20151747.1/2206A/R1/BW

22/06/2016

80-88 Regent Street, Redfern - Response to Council Comments

This letter details the response to the comments received from the City of Sydney Council regarding the DA Noise and Vibration Impact Assessment conducted for the 80-88 Regent Street, Redfern project.

Childcare  
outdoor  
area below

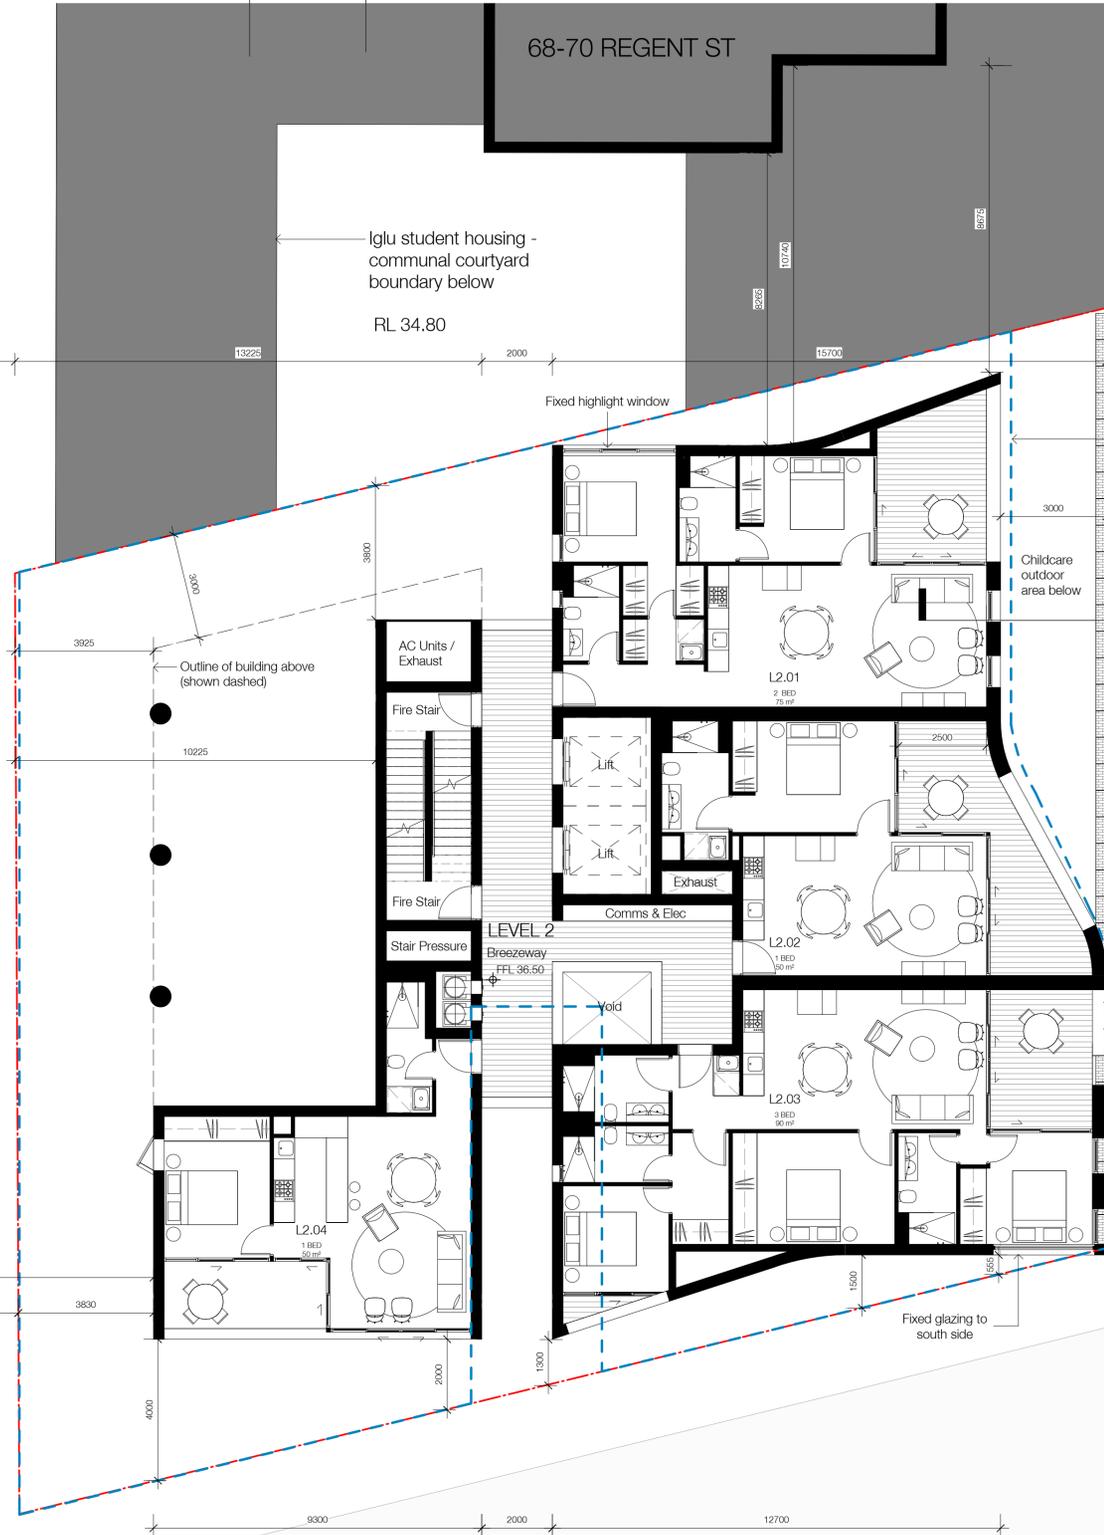
- Signs reminding staff and visitors to minimise noise at all times shall be installed at ingress/egress points from the child care centre.
- The underside of the building structure to the west which over hangs the proposed external area is to be acoustically absorptive treatment such as envirospray, absorptive insulation or the like. Treatments should be to a minimum of 40% of the soffit area. Details to be provided at the CC stage of the project.
